**Re: Noon Day
2500 Second St NW
Request Permanent C.O. - Accepted
Engineer's Stamp dated: 12-5-13 (H14D067)
Certification dated: 11-26-14**

**RE: Grading and Drainage Plan
Noon Day (H14-D067D)**

RE: **Noon Day, 2500 2nd St**
Grading and Drainage Plan
Engineers Stamp Date 12/05/13 (H14-D067)
Engineer's Certification Date 11/4/2014

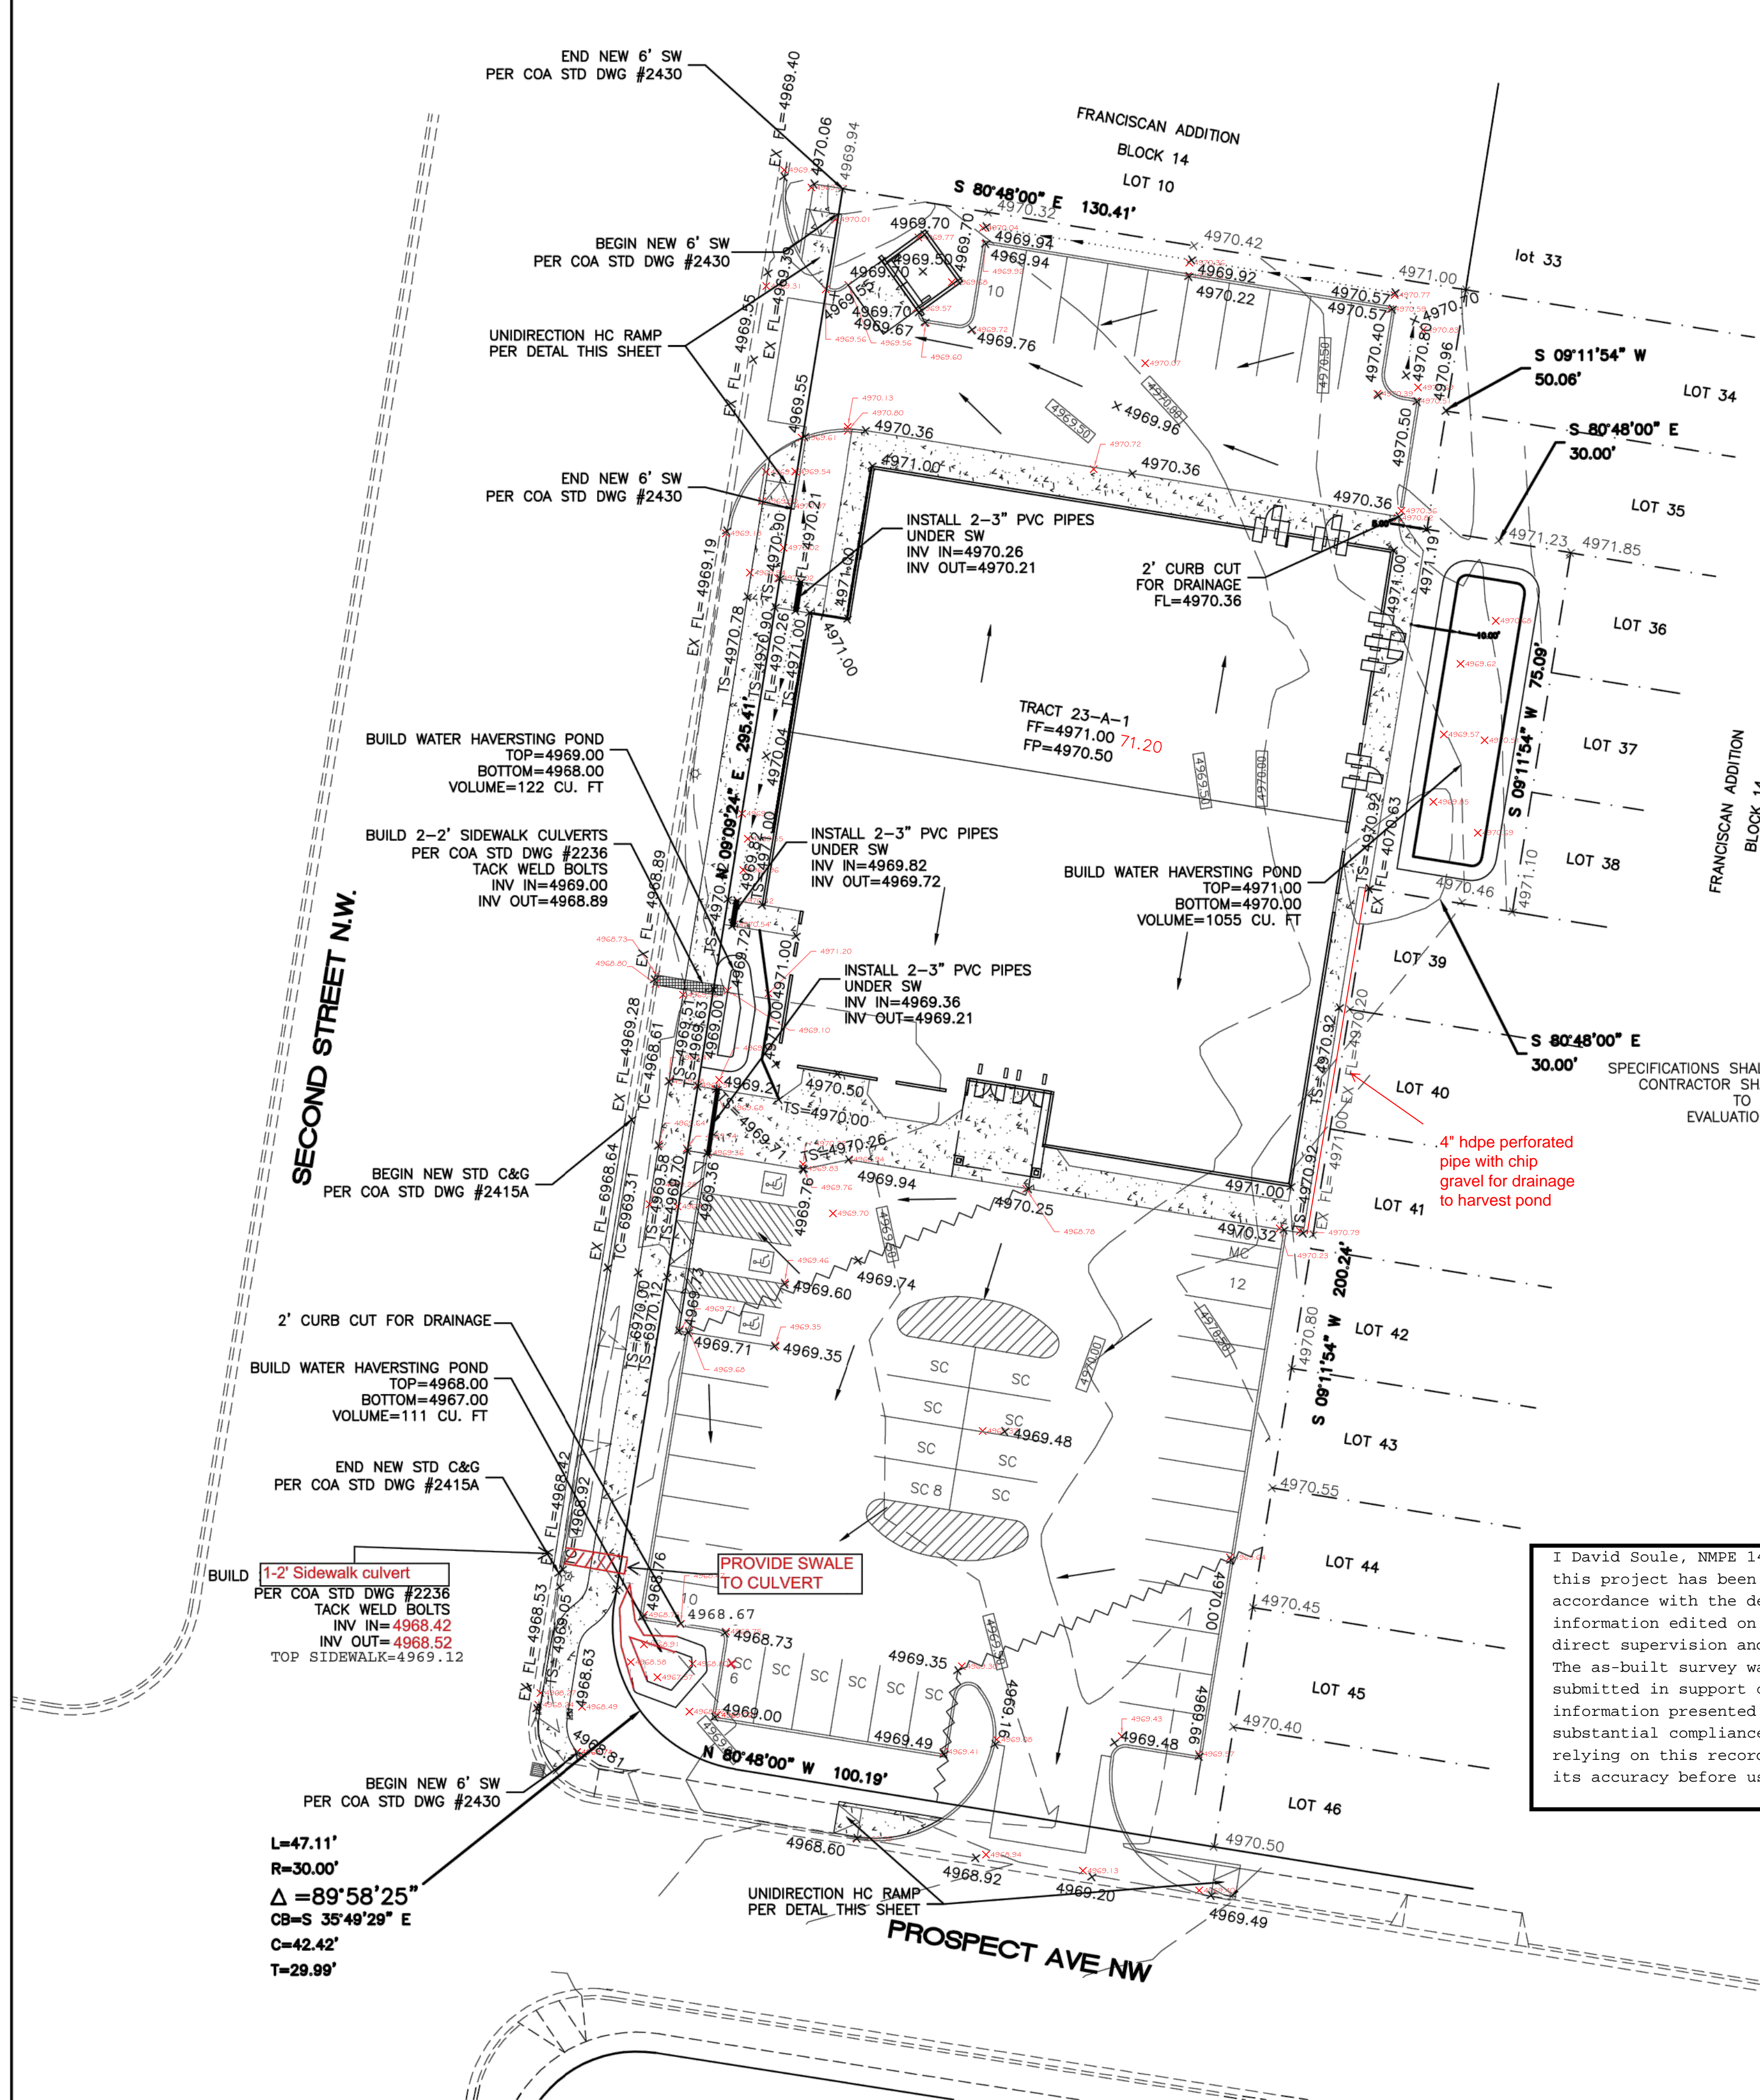
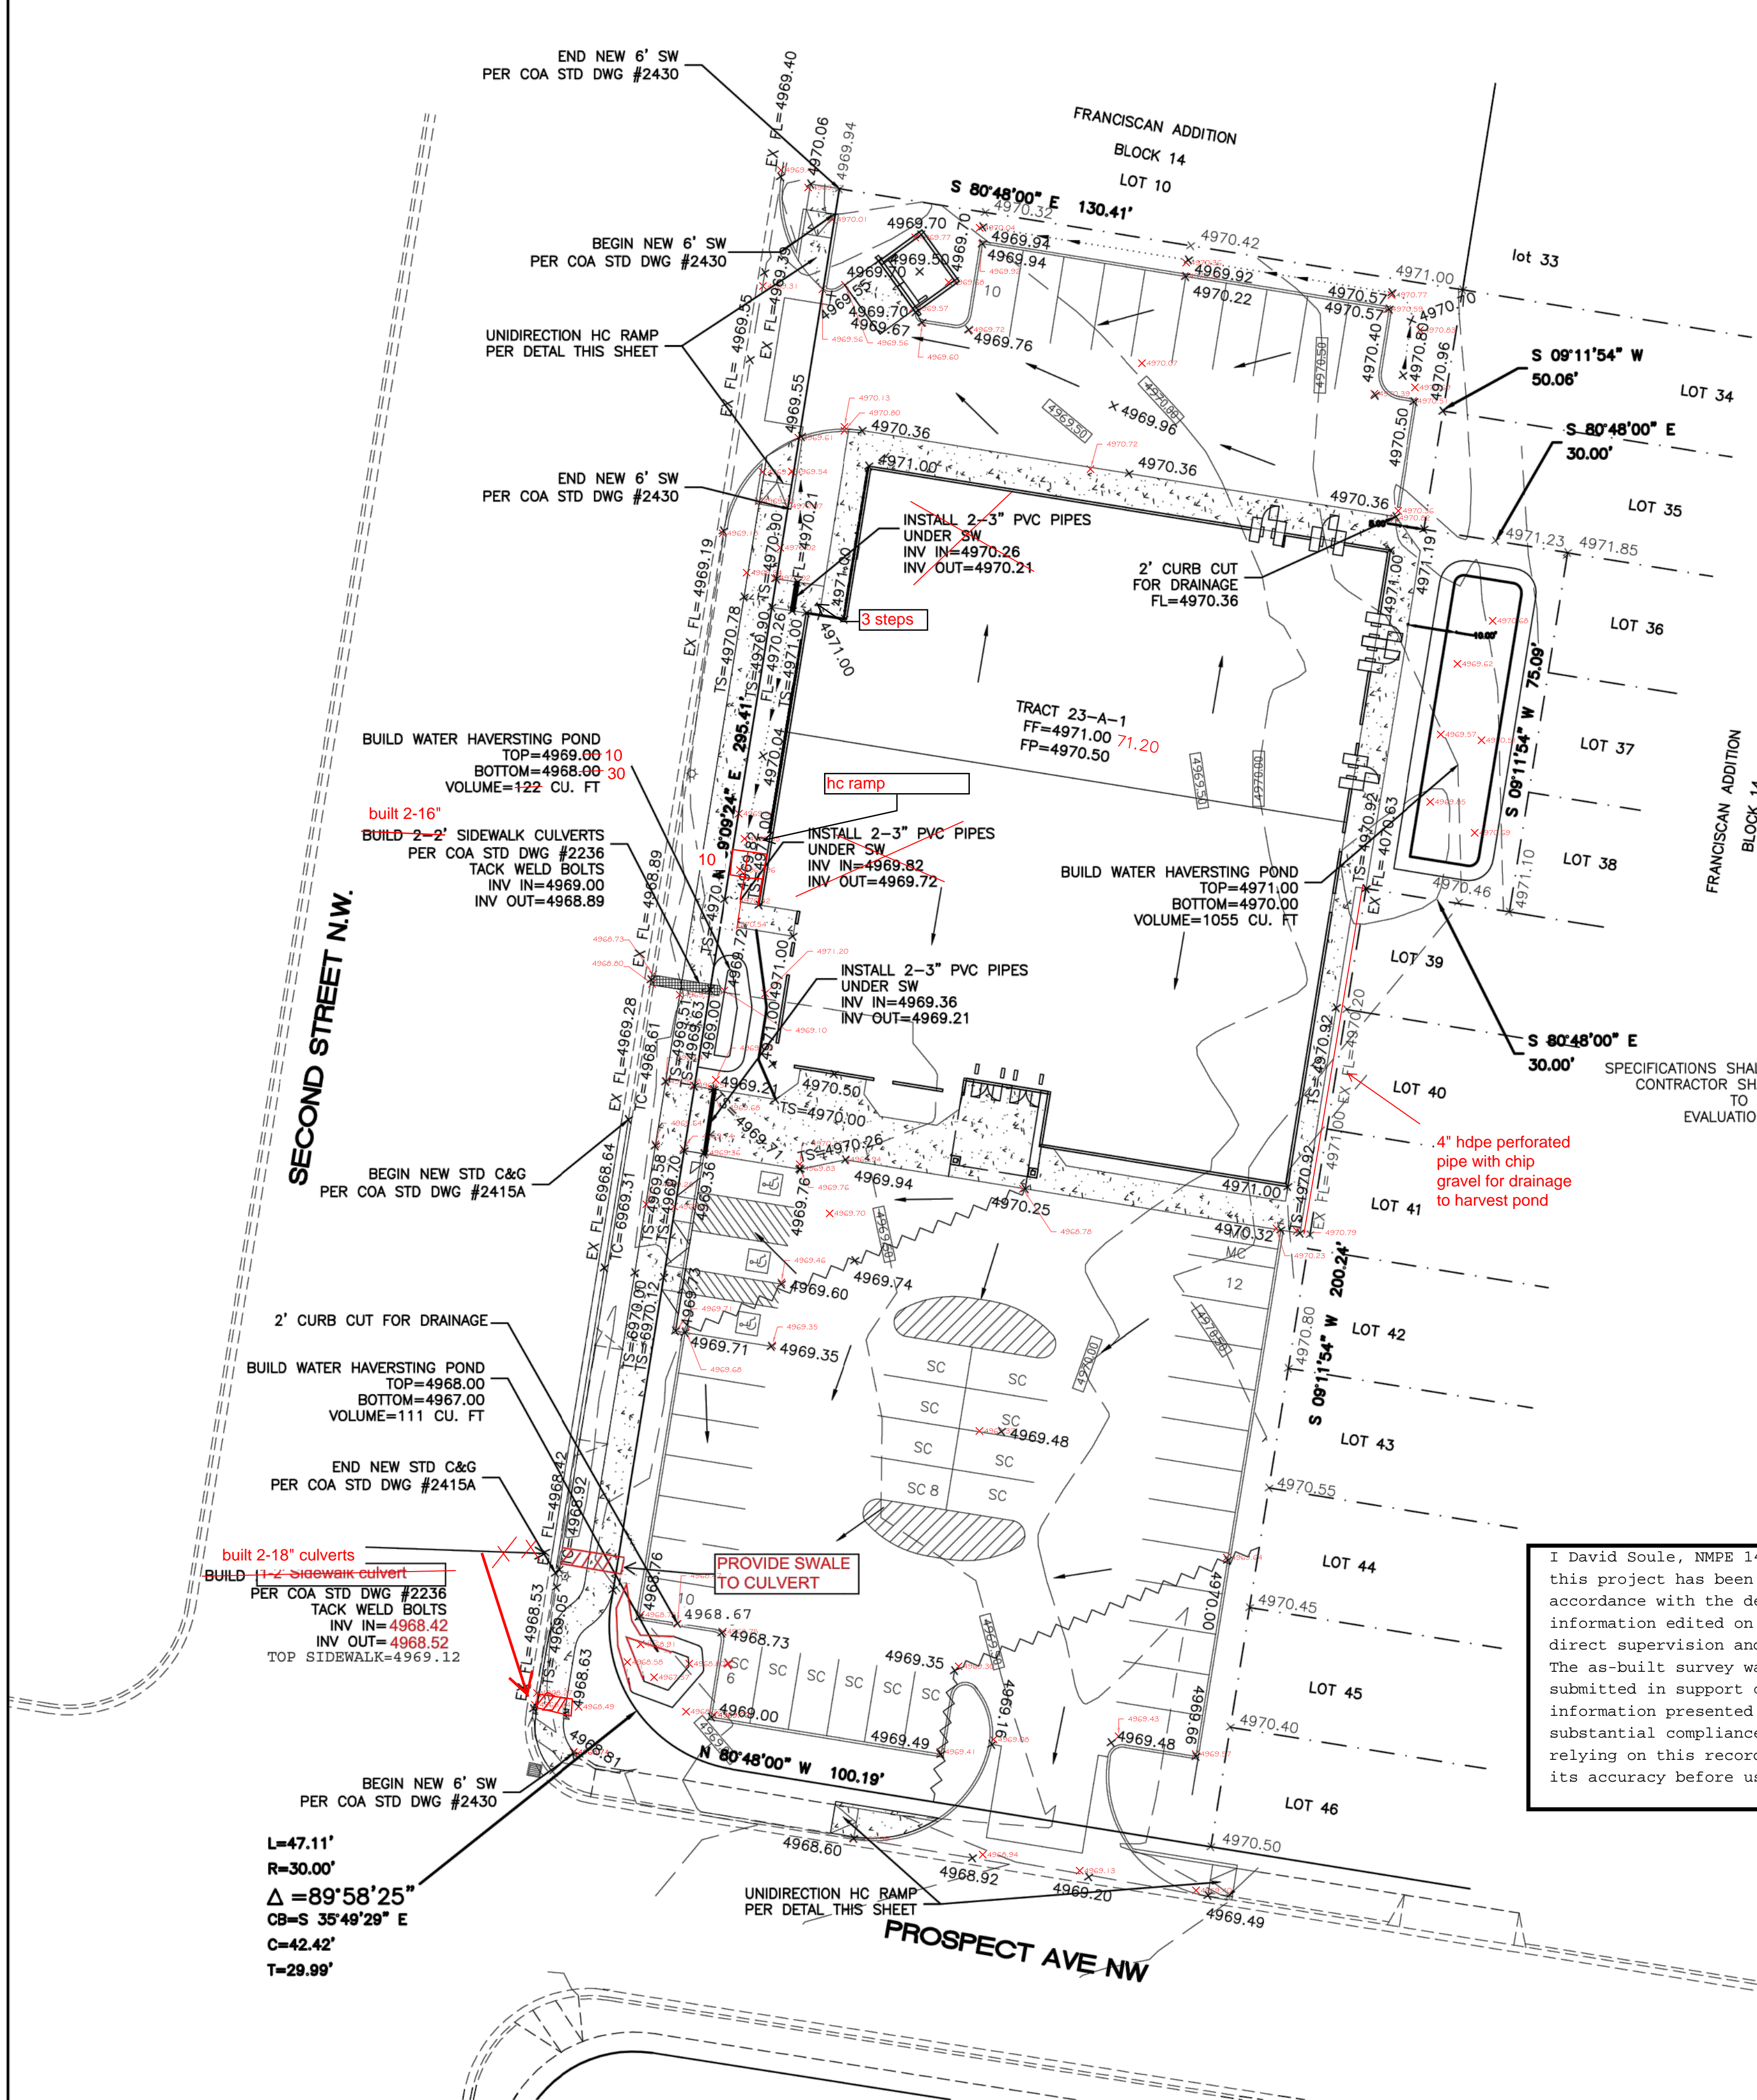
- provide calculations showing that the as-built width of the north sidewalk culverts is sufficient for drainage. It is built 17" wide but G&D calls for a 24" wide.
- On the north culvert, there is no expansion on both ends. Give room to have the 6" space for expansion on both ends. There is also no bar on street end of plate.
- The south culvert has a cracked center with missing concrete at face creating a tripping hazard. Recommendation is to remove south culvert, saw cut at cold joint ramp end.
- There is a cracked north side curb at cold joint through the back of curb, epoxy over bolts

North culvert plates 2 feet with 17 inch openings plan calls for two 24 inch. Plate is welded but there is no expansion on both ends the plate is painted no other deficiencies

South culvert is a no pass cracked center with missing concrete at face tripping hazard. Cracked north side curb at cold joint through back of curb, epoxy over bolts. And no bar on street end of plate, openings are 17 inches. Recommendation is to remove south culvert saw cut at cold joint ramp end. North to give room to have the 6 inch space to expansion at both ends

The purpose of this letter is to accompany the enclosed calculation to prove the proposed 2' sidewalk culvert that was constructed as a 16" culvert has the capacity to convey the contributing flow. Should you have any questions regarding this re-submittal, please do not hesitate to call me.

$$Q = 2.95 \times 1.5 \times 0.67^{1.5} = 2.42$$

there are two culverts so

$Q_{\text{allowable}} = 4.84 \text{ cfs} > Q_{\text{required}} = 1.85$
